City of Albuquerque

October 17, 1988

RE: REVISED GRADING & PAVING PLAN FOR EL BUENO SAMARITANO CHURCH
(J-14/D76) RECEIVED SEPTEMBER 30, 1988

GRADING AND DRAINAGE PLAN
FOR NEW PARKING LOT
EL BUEN SAMARITANO
UNITED METHODIST CHURCH
(7TH STREET N.W. & GRANITE AVENUE N.W.)
ALBUQUERQUE, NEW MEXICO
DECEMBER, 1988

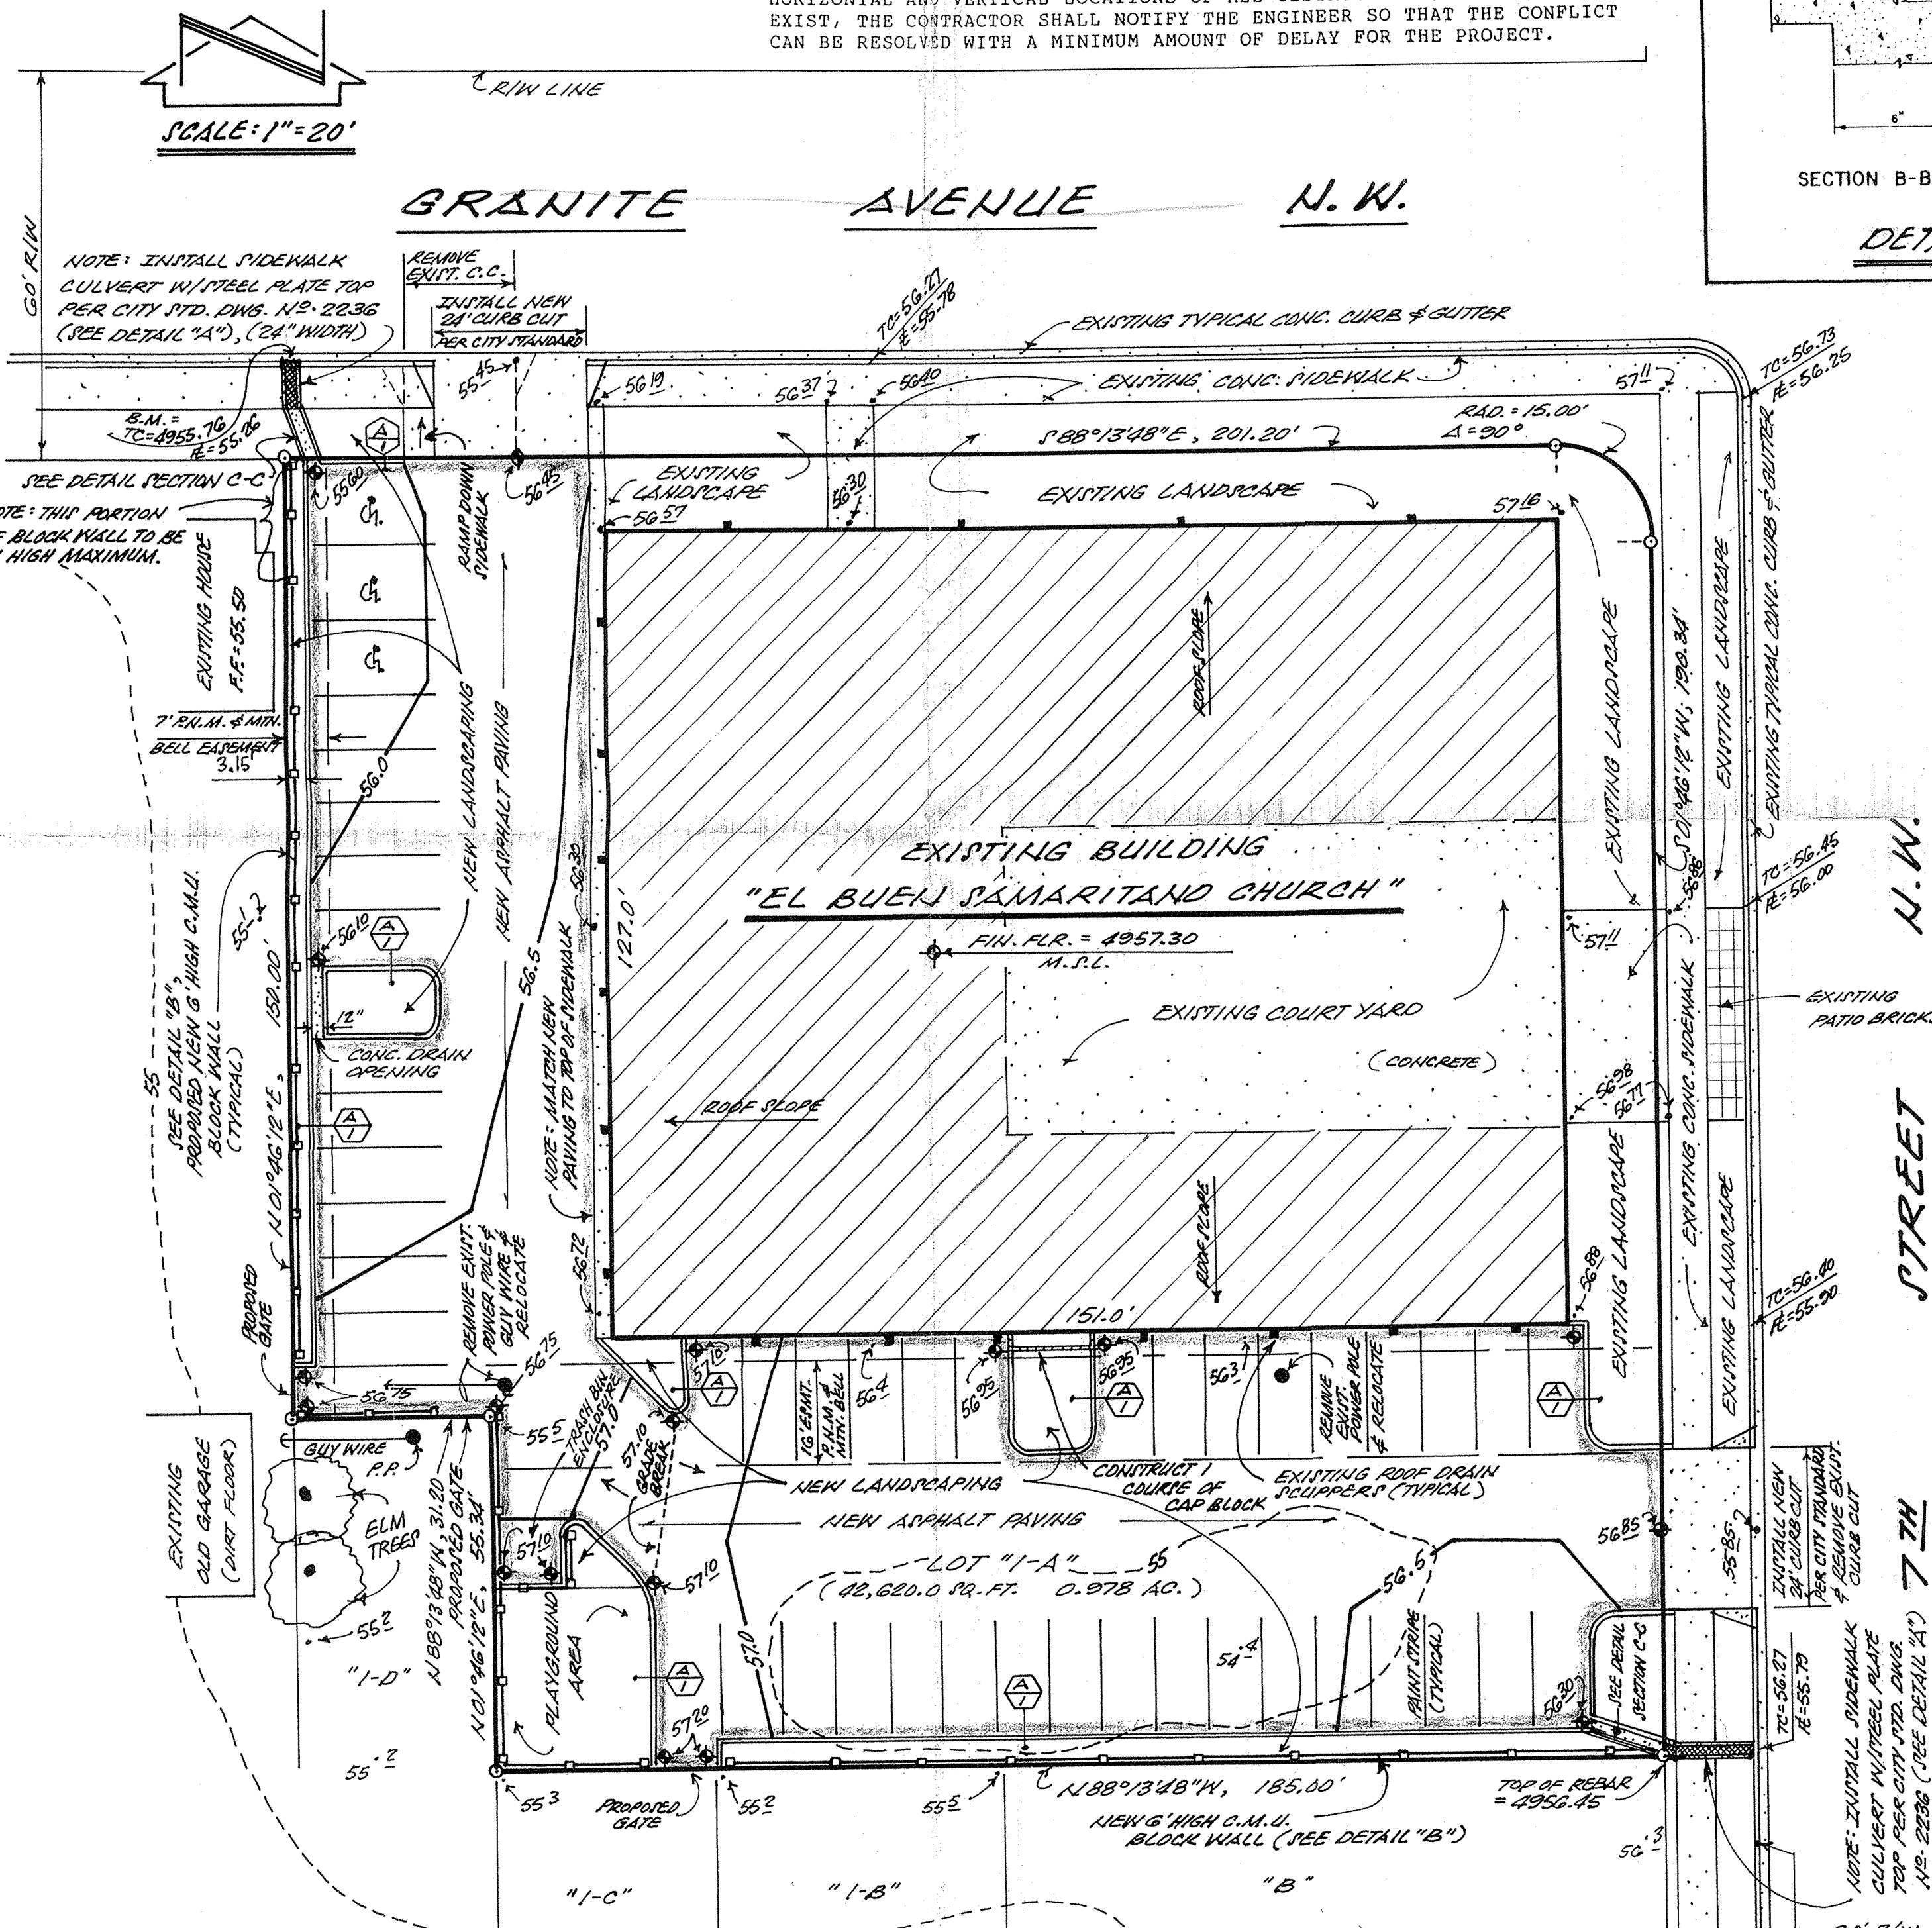
1. You must indicate the 100 year water surface elevation on the plan drawing.
2. Your inlet calculations indicate that the proposed catch basin will be operating under what is required. What will happen is that the runoff will pond and then spill over to the adjacent property. You will need to treat the inlet as a weir to the point where it will start overflowing, then you will treat it as an orifice.
3. Your plan indicates that the invert at the proposed catch basin is at 49.00 and the invert at the manhole is at 49.21, this indicates an opposite flow pattern. Please address.
4. Please indicate what area of the existing roof drainage will be routed towards the proposed catch basin.
5. I will still need concurrence from DRC of first review.
